My ref: RLS/18.02/17/AR
Your ref: A/176/17/PL

25th October 2017

Application for 2 Detached Dwellings.
Land at the "Ninth Tee", Ham Manor Way, Angmering.

Site Plan (1:200)

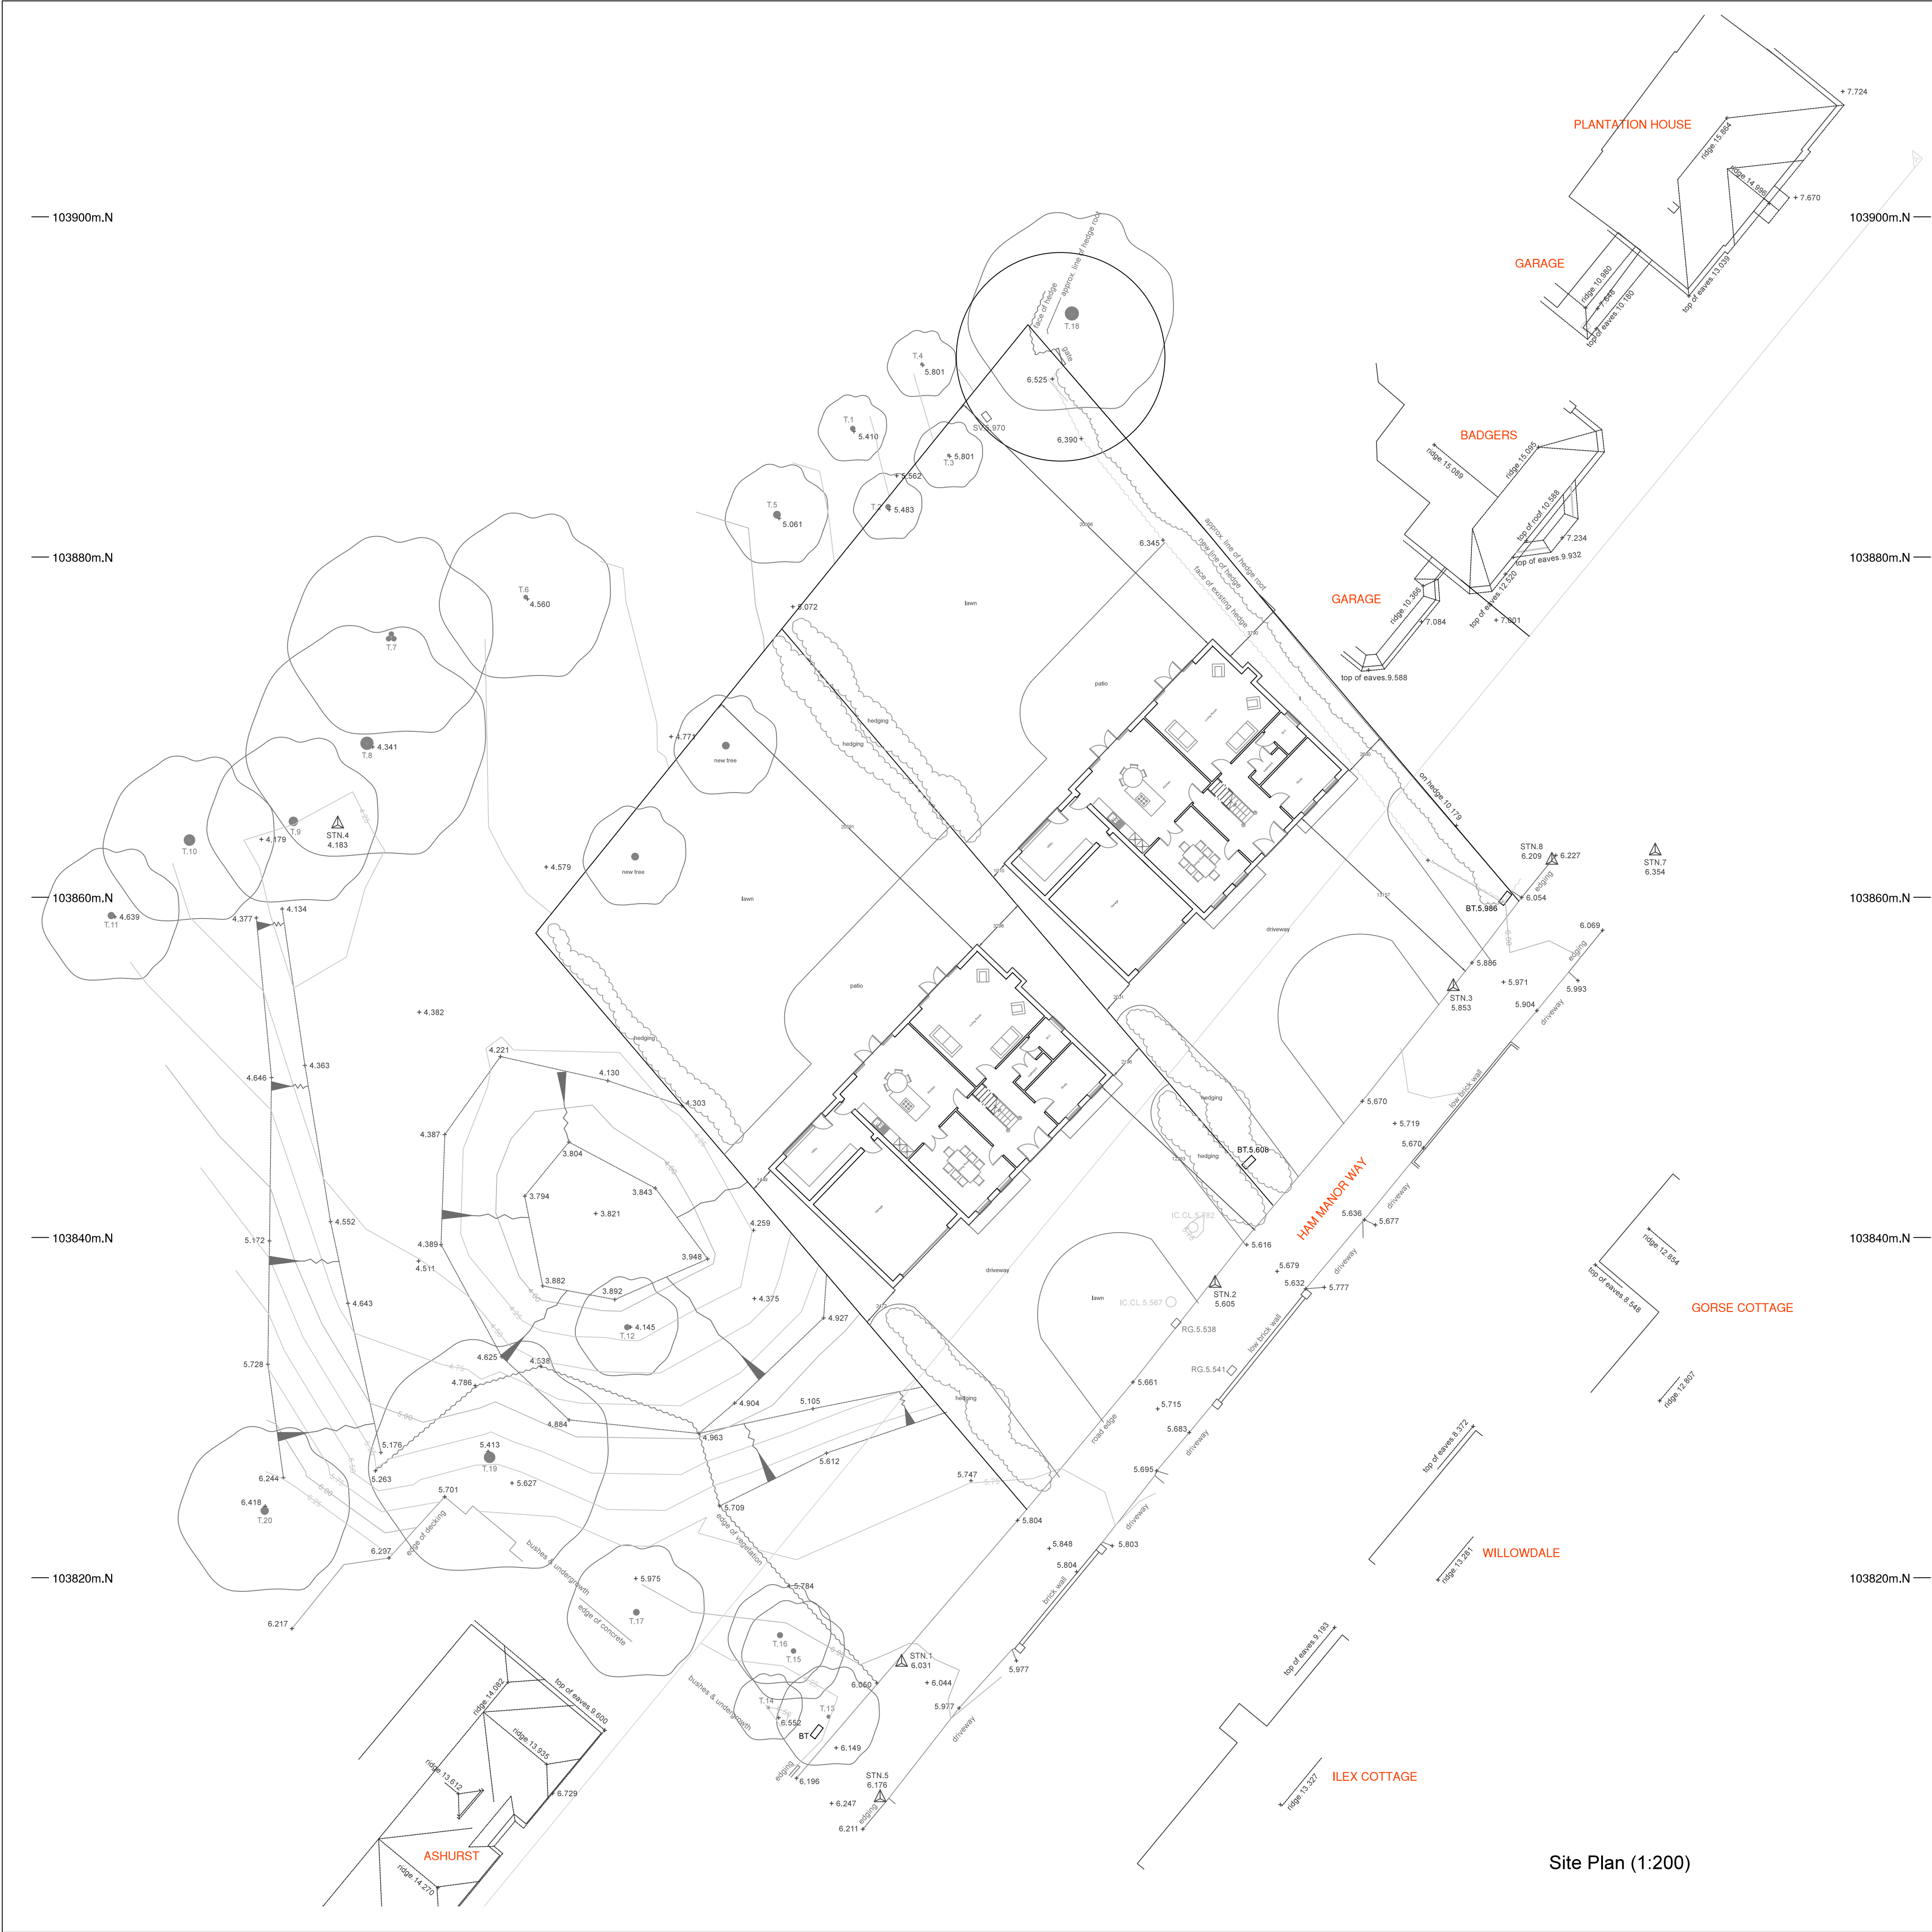
1. Given the size of the proposed dwelling it is our opinion that this development will significantly affect his long established boundary hedgerow on the south side of his property. We maintain that this long established hedgerow could be the subject of a dramatic cutback along much of its length to allow the development to proceed. This is particularly of concern that the two-storey development adjoins his south boundary. When you view the site you will see that presence of the hedge along the whole southern boundary of his property and its potential for a dramatic cutback which will create a wholly unacceptable loss with intrusion

Whilst this is a boundary hedgerow reference is made to this hedge on the submitted plans, although we are not convinced it is accurately shown in terms of the scale, particularly its width, of its potential impact upon this proposed development. I am sure you can imagine when viewing this hedge the impact of this building upon that hedgerow. Historically, and quite rightly so, no one has expressed concern over the hedgerow as it has adjoined and spread across the neighbouring golf club land where it actually has no impact at all and indeed gives a sense of enclosure to this open amenity space. This is clearly a major concern for my client. Furthermore, at the western end of this hedgerow there is a gated entrance into the golf club land which is long-standing and is permitted by the golf club. This actual entrance from his rear garden will now go into the adjoining private garden and is therefore of no consequence in giving him access onto the golf club land.

Side Elevation (north-east)

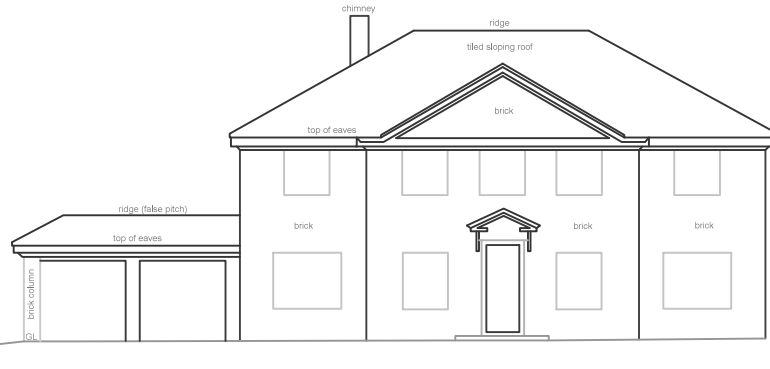
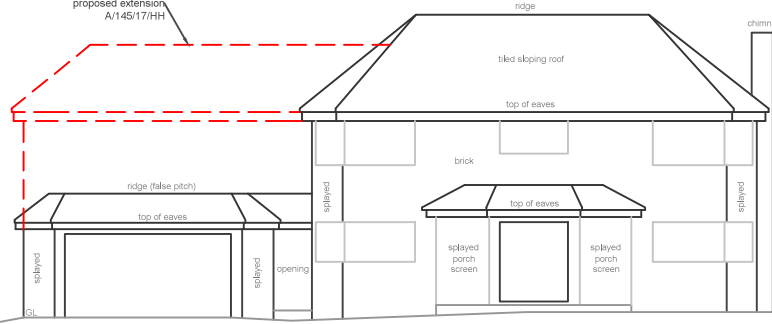
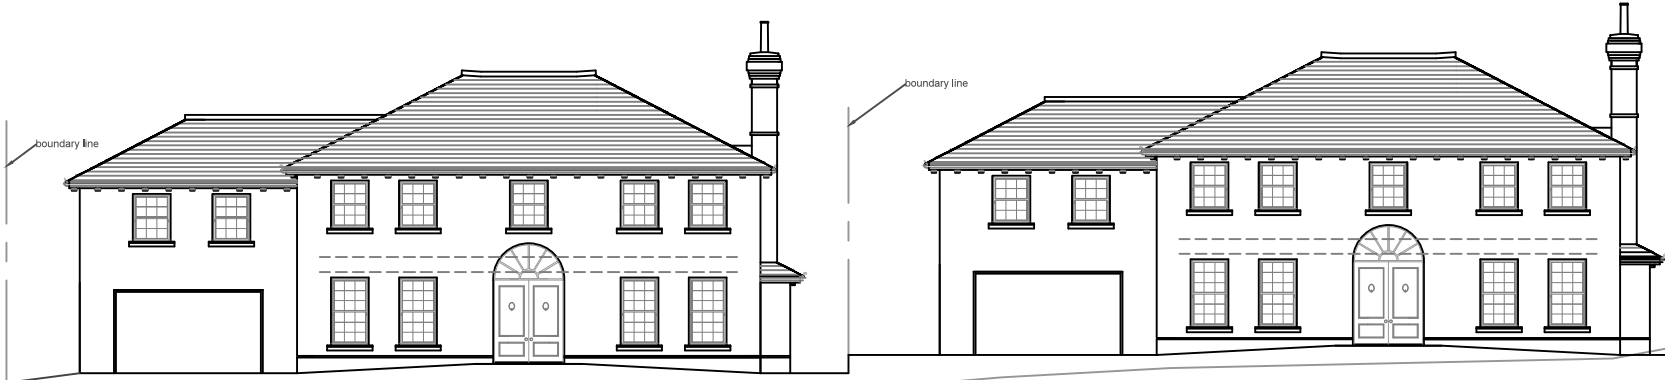
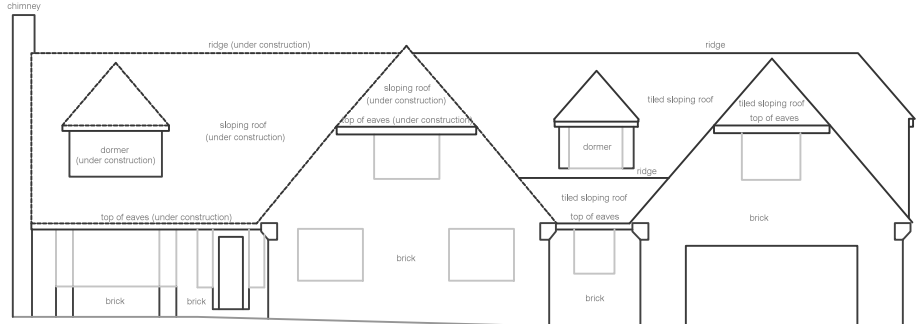
2. My client has recently received planning permission for a first floor extension to his property with an important bedroom on the south elevation. This elevation will now face directly south and into the side elevation of the proposed new dwelling. The impact upon the window will be quite unacceptable. Firstly, the window provides an opportunity for a quality source of light into the room on the south elevation which will suffer loss of natural daylight particularly in the winter. Secondly, the outlook will be unacceptably harmed by the introduction of the building resulting in an unacceptable loss of light and outlook. Clearly the potential here is much greater and unacceptable to my client where, as before, when the application was prepared and submitted the outlook from this window was on to the open space of the existing golf club and views through in itself would have been attractive unlike the outlook onto the side elevation of this dwelling.
